City of Portland, Maine - Building or Use Permit Application

Permit No: 03-0236	Issue Date: APR 09 2003	CBL: 217 B054001
-----------------------	-----------------------------------	---------------------

Proposed Project Description: Construct 32'x27' 6" Single Family Home w/20'x16' Family Room and 28'x24' Attached Garage	Signature: <i>JMB 4/9/03</i>
PEDESTRIAN ACTIVITIES DISTRICT (P.A.D.)	
Action: <input type="checkbox"/> Approved <input type="checkbox"/> Approved w/Conditions <input type="checkbox"/> Denied	
Signature: _____ Date: _____

RE: Site Plan for Lot 24 River's Edge, Captain's Landing

SITE PLAN

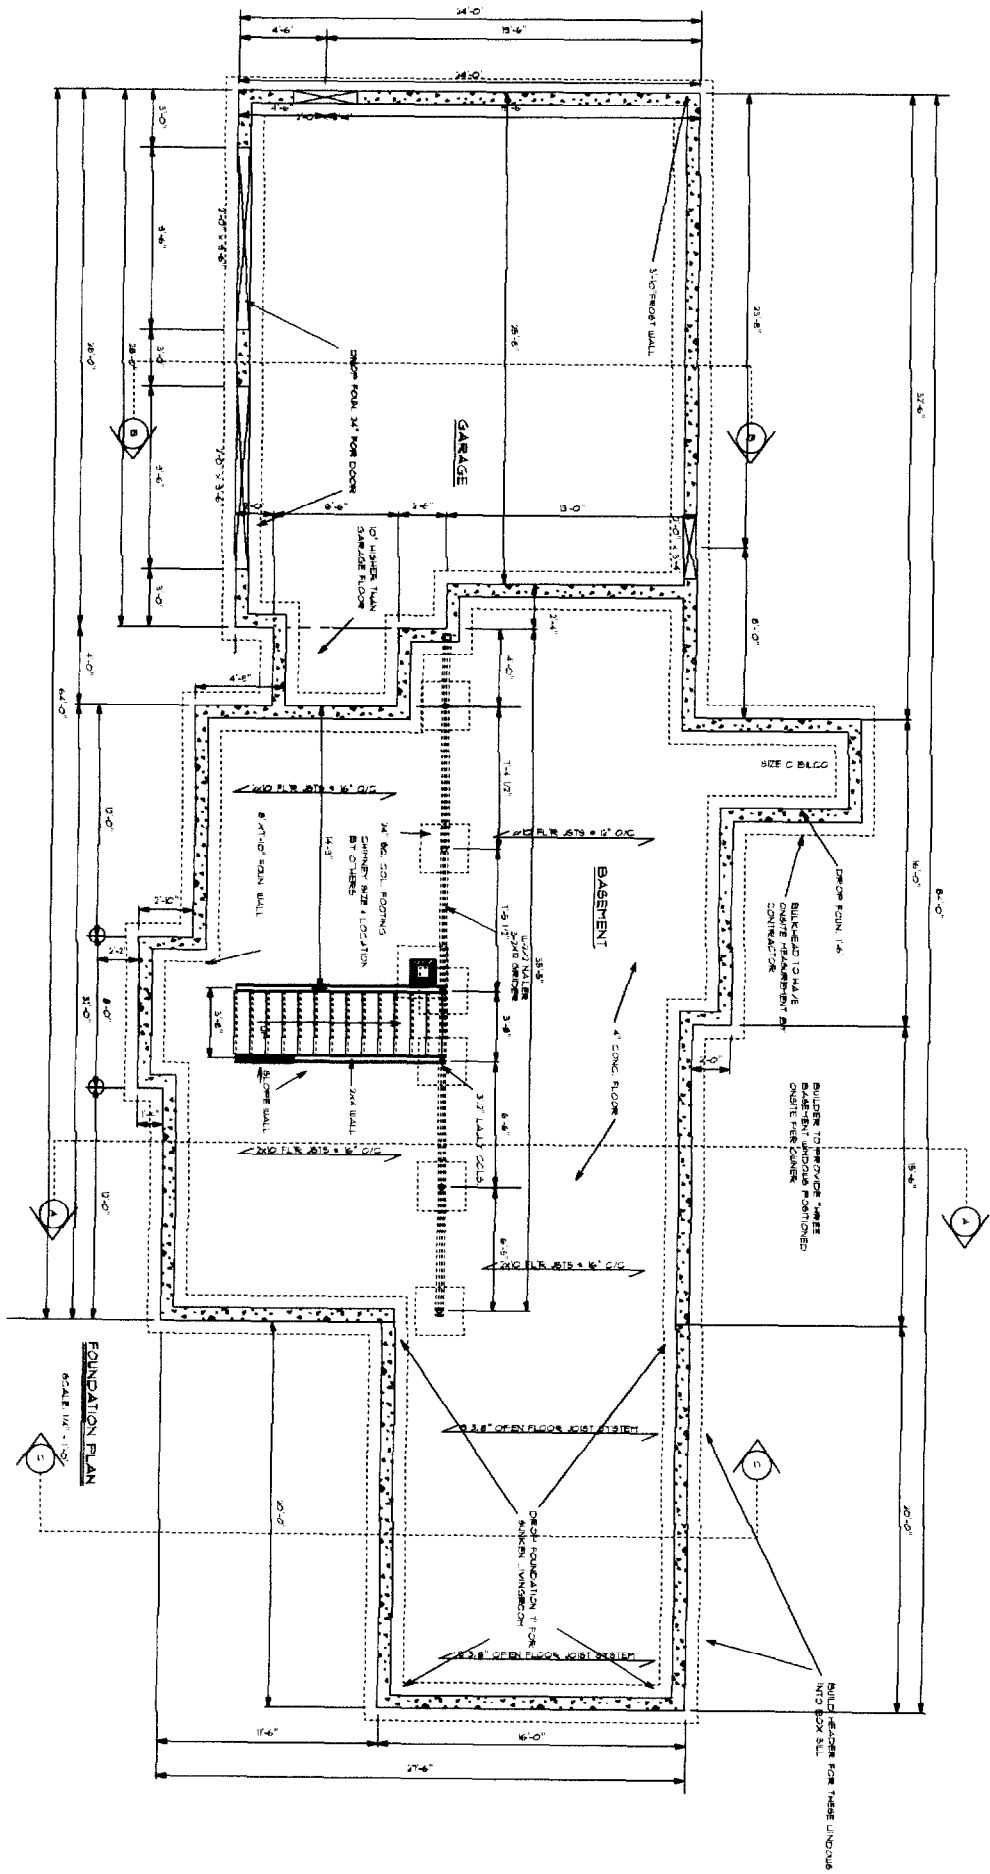
Enclosed is a revised Site Plan for your project. We have discovered that it was plotted at the wrong scale. The dimensions shown are correct but scaling the Plan will result in errors.

Please destroy all existing copies of the Site Plan and replace it with the enclosed copy.

TYPICAL FOUNDATION WALL SECTION - MAIN HOUSE

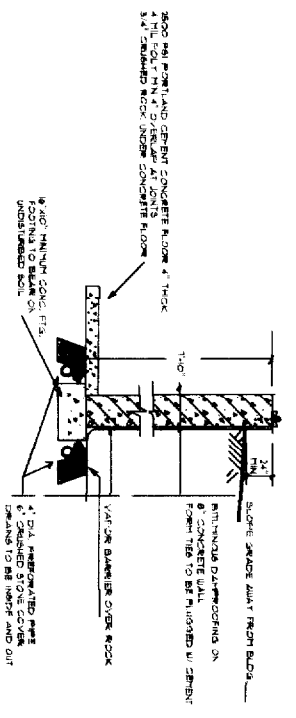
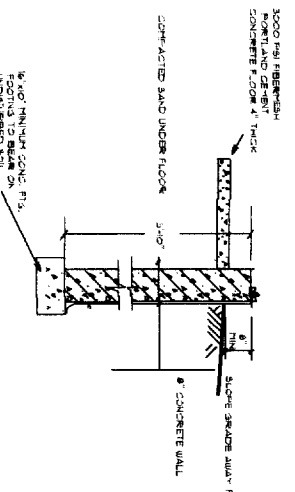
- 1) Soil presumptive value will be determined at excavation. Footing size is 16" which is adequate for load bearing to 2000psf, any less would require a larger dimension footing.
- 2) Separate permits are required for any electrical or plumbing work.
- 3) Application approval based upon information provided by applicant. Any deviation from approved plans requires separate review and approval prior to work.
